Our ref: 107016

8 May 2020

SSD 7874 Redevelopment of the Harbourside Shopping Centre
Submission on Visual Effects and Impacts of proposed amended application

SECTION ENVELOPE Section 1
1:500

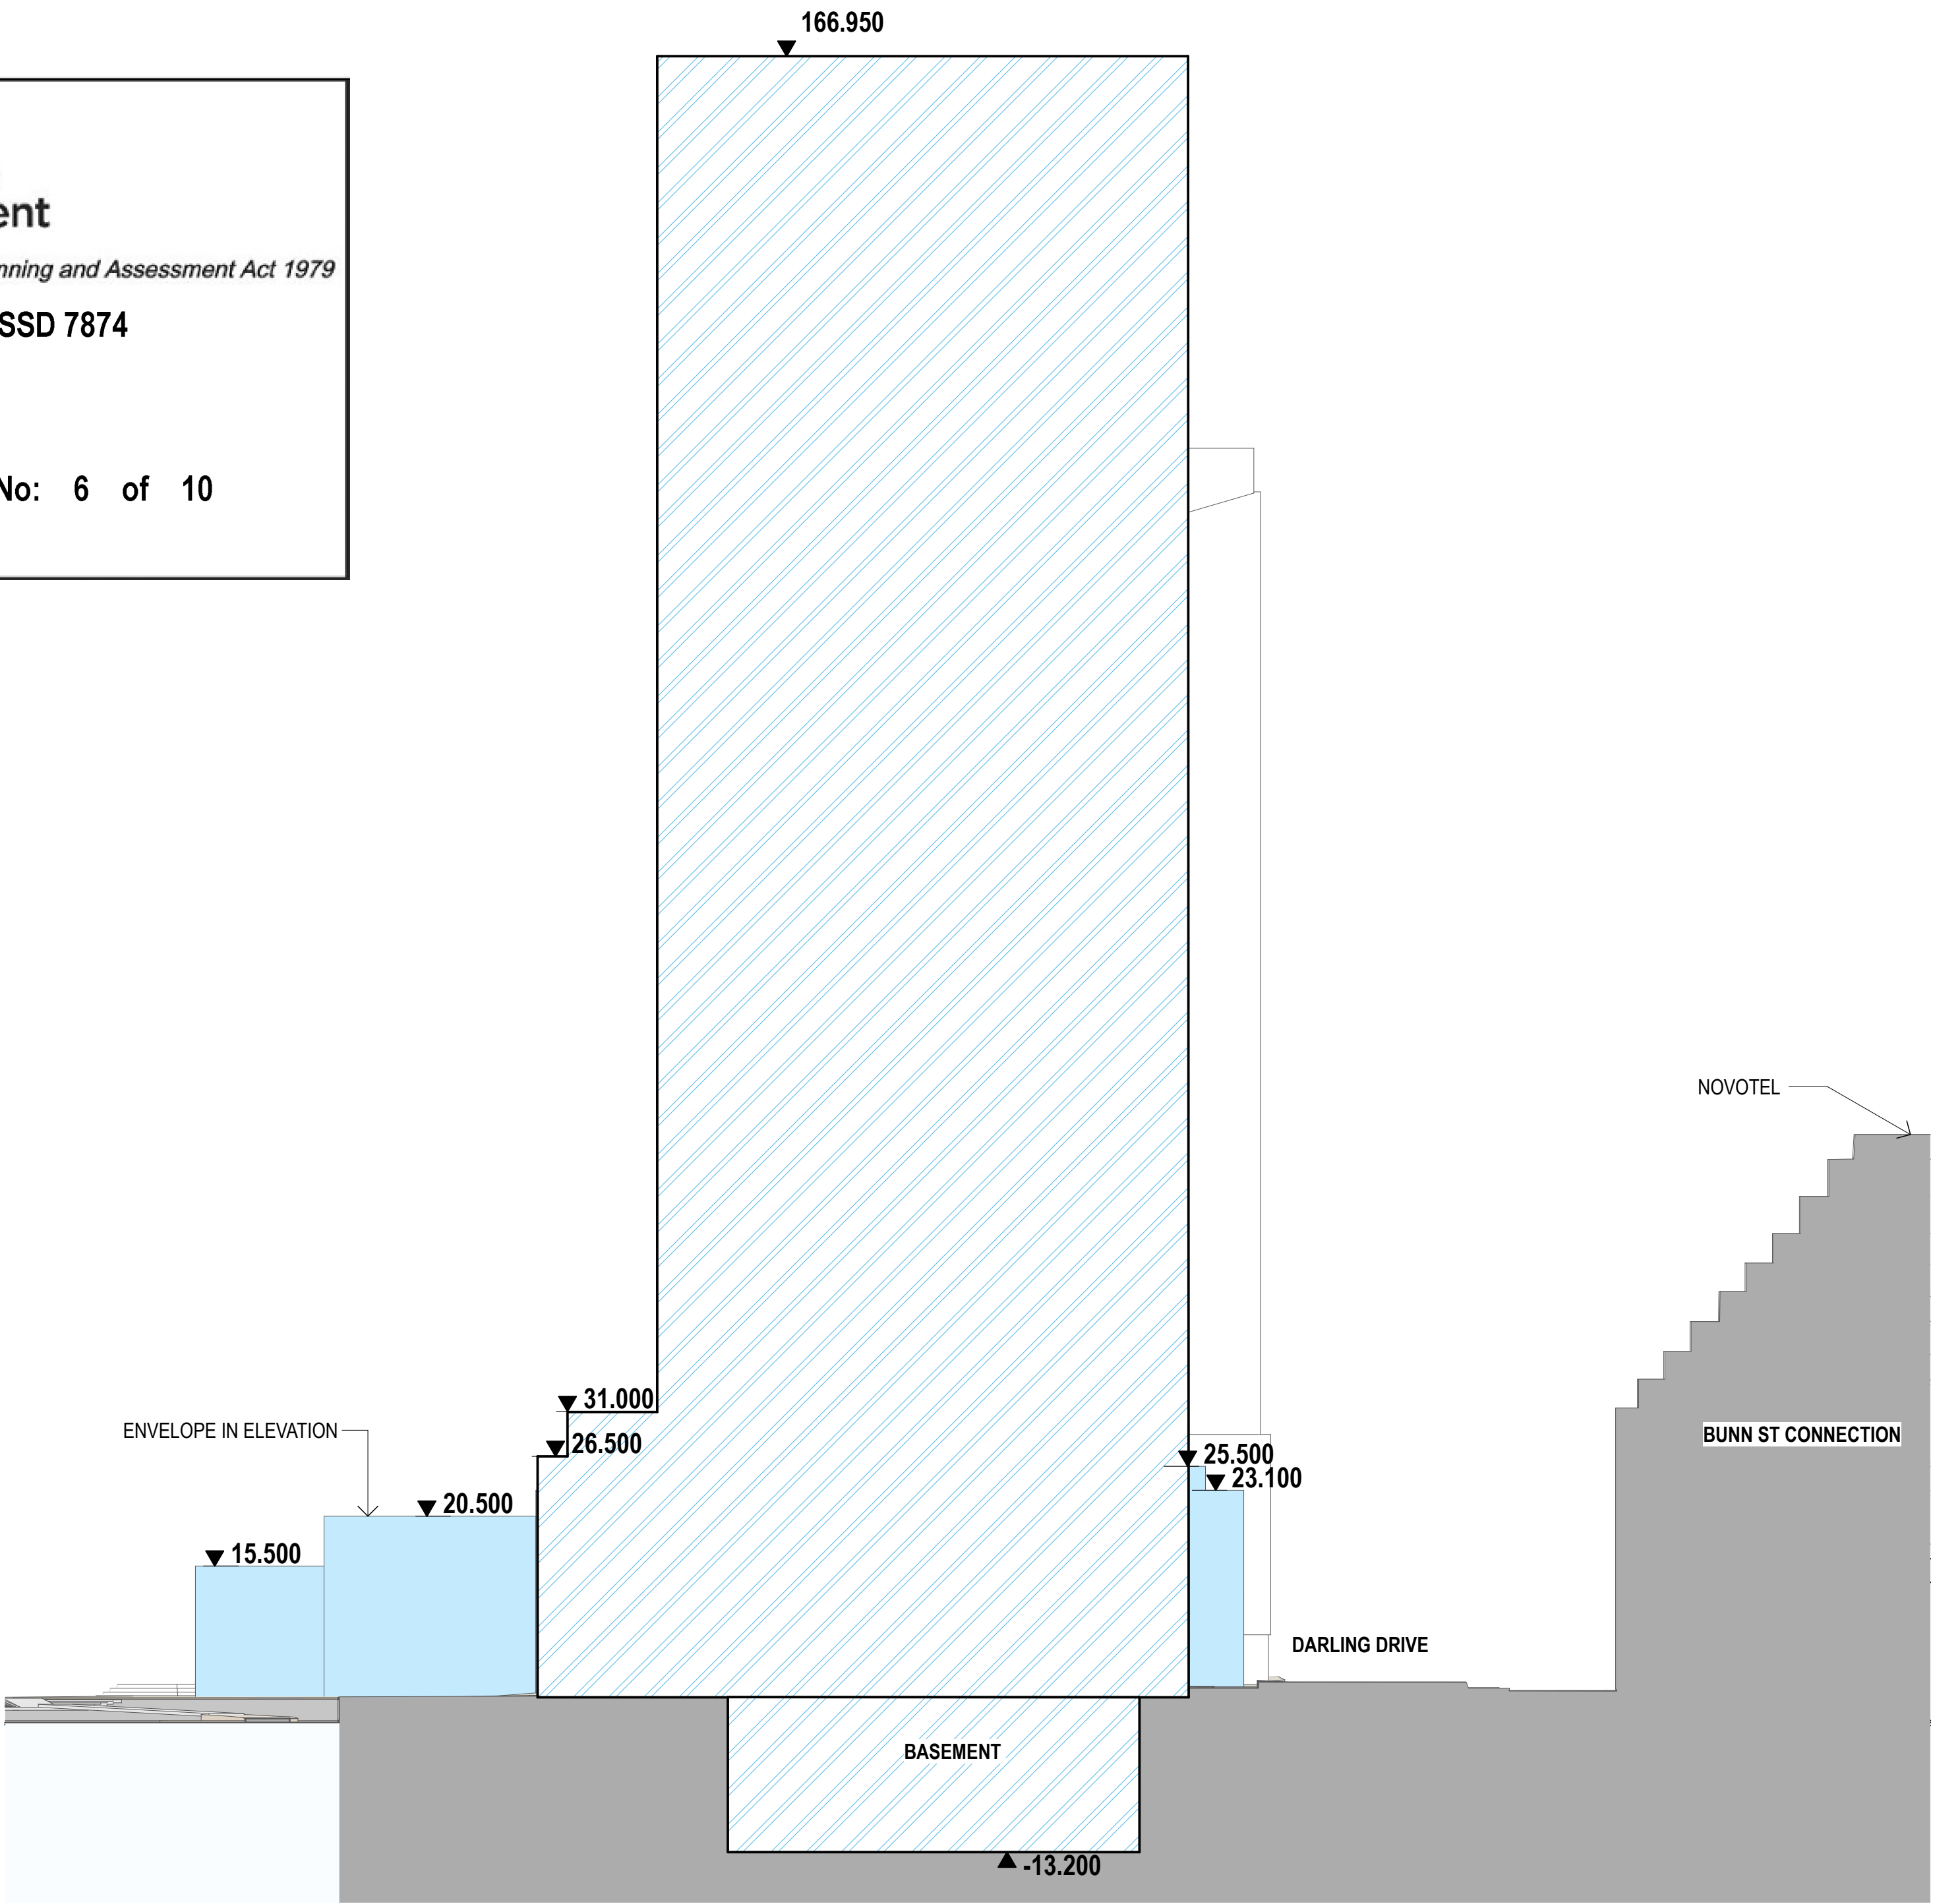
The proposed podium directly east of One Darling Harbour will have a height predominantly to RL25m, or 7.55m higher than the existing ridge of the Harbourside building. The podium is of up to six commercial storeys in height above the decking level. The commercial floor to floor heights proposed are greater than in the existing Harbourside building. Therefore, even if it was of the same number of levels as the existing Harbourside building east of One Darling Harbour, the podium will cause greater view loss than the existing building.

The envelope of the podium has no articulation in the section directly east of One Darling Harbour and is flat, whereas the existing Harbourside building has a pitched roof, allowing downward views over it from some residential apartment levels in One Darling Harbour. Thus the impacts of the envelope on views from levels of One Darling Harbour would be underestimated in the modified application for those levels with similar or somewhat higher eye heights to the ridge of the existing Harbourside building.

The reason for this underestimation is that the trailing edge of the podium, toward the water, is both higher than the existing ridge of the Harbourside building and also extends horizontally into the view line, whereas the existing built form of the Harbourside building slopes down beyond the ridge. This allows views to exist toward the land-water interface and the water in Cockle Bay downward over the sloping roofs, for levels of apartments in One Darling Harbour that are currently above the ridge height of the Harbourside building, views from which would be blocked by the proposed podium.

The podium is also proposed to step upward on the north side of the base of the tower to a maximum of RL31m north of the tower. This part of the podium, at 13.6m higher than the ridge of the existing Harbourside building, will have significant impacts on views to the south-east from One Darling Harbour. For the northern part of the podium therefore, the proposed podium varies from 7.6m to 13.6m higher than the ridge of the Harbourside building. This is equivalent to approximately 2.5 – 4.5 residential storeys. Clearly, apartments in One Darling Harbour over a significant part of the building will experience significant view loss caused by the height and the massing of the podium.

In my opinion the height and the east-west depth of the northern section of the podium causes significant view loss that has not been acknowledged and should be reconsidered, if the overall strategy for redevelopment, with a podium-tower building is accepted. These features of the proposal do not achieve a reasonable view sharing outcome.
